WEST SUSSEX COUNTY COUNCIL CONSULTATION

TO:	<u>Arun</u> District Council FAO: Raymond Cole
FROM:	Stephen Gee <u>WSCC</u> - Highways Authority
DATE:	16 March 2021
LOCATION:	<u>GTR</u> land east of <u>Fontwell</u> Avenue <u>Arundel</u> Road <u>Arundel</u> <u>BN18 0SB</u>
SUBJECT:	<u>BN/18/21/PL</u> 5000 sq m of light industrial floor space (ClassB1 (b)/(c) following grant of outline planning permission WA/22/15/OUT (resubmission following BN/57/19/RES). This site is in CIL Zone 1 (Zero Rated) as other development.
DATE OF SITE VISIT:	n/a
RECOMMENDATION:	Advice / No Objection
S106 CONTRIBUTION TOTAL:	n/a

WM/688/P502

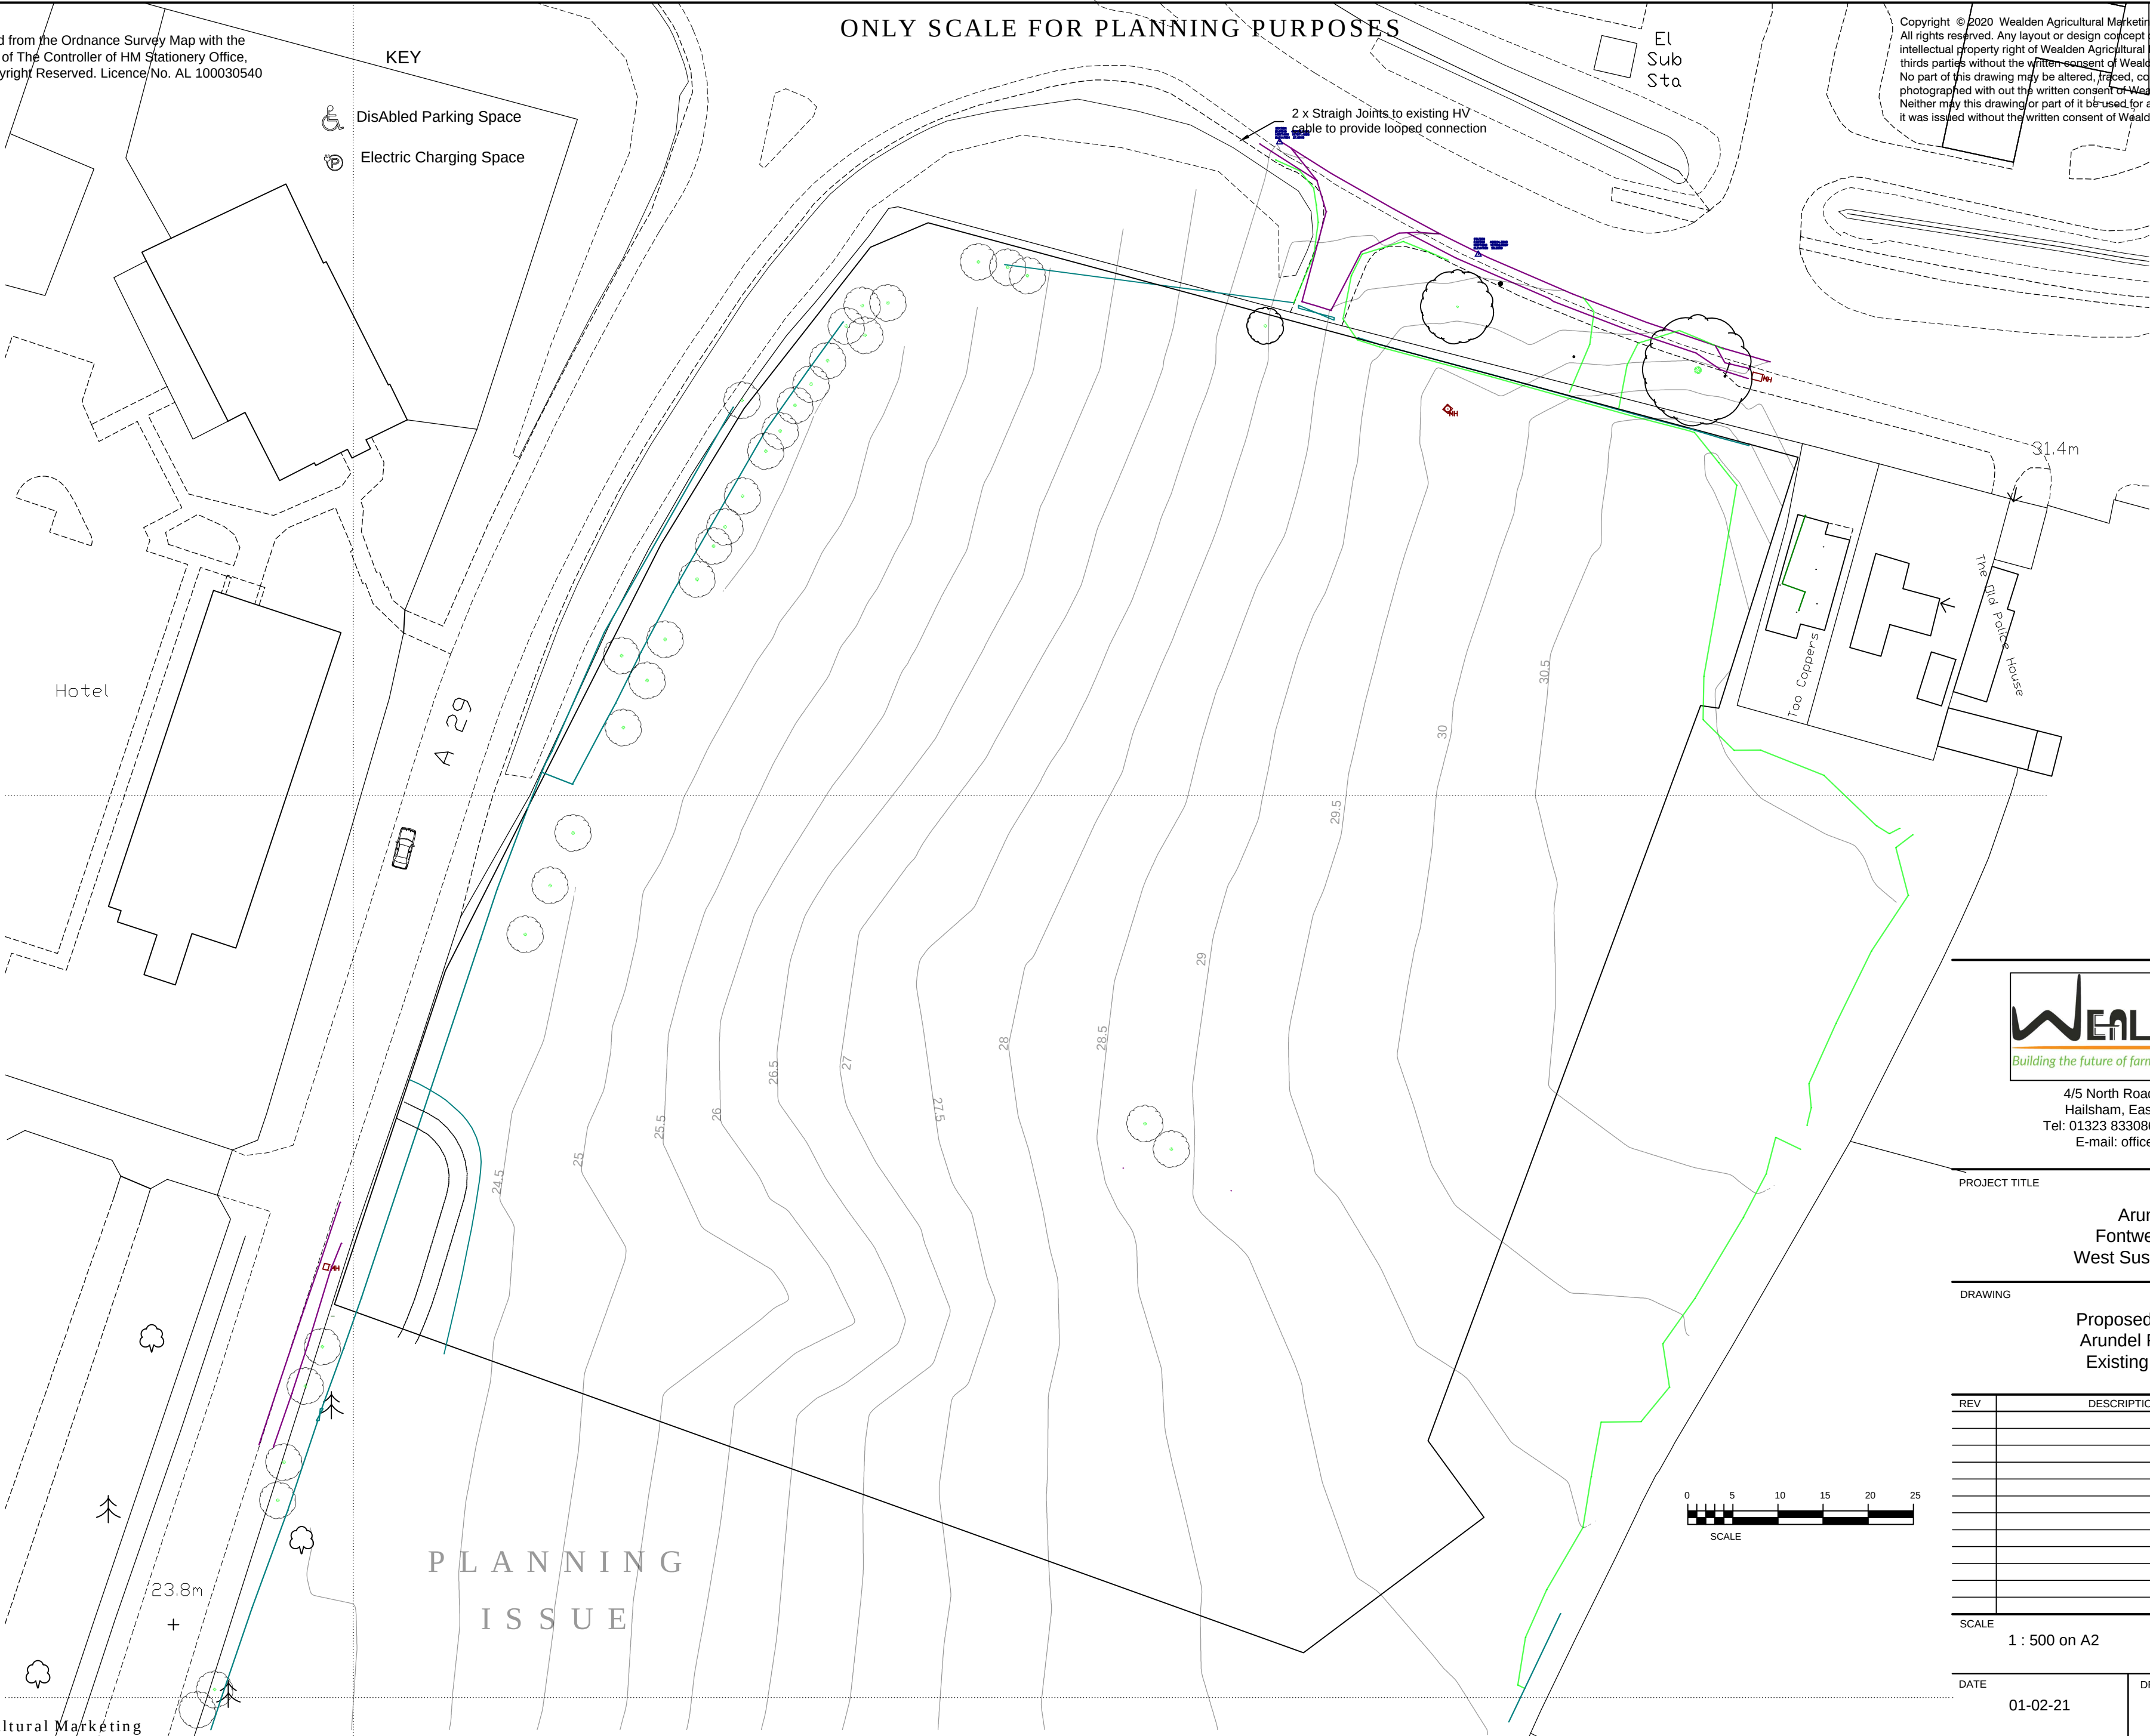
It is noted that a reduction of 5 electric vehicle charging spaces are shown in the western parking area from the previous application. It is recommended that the total provision is checked against the Arun policy requirements.

No part of the development shall be first occupied until Electric Vehicle Charging spaces have been provided in accordance with plans and details submitted to and approved by the Local Planning Authority.
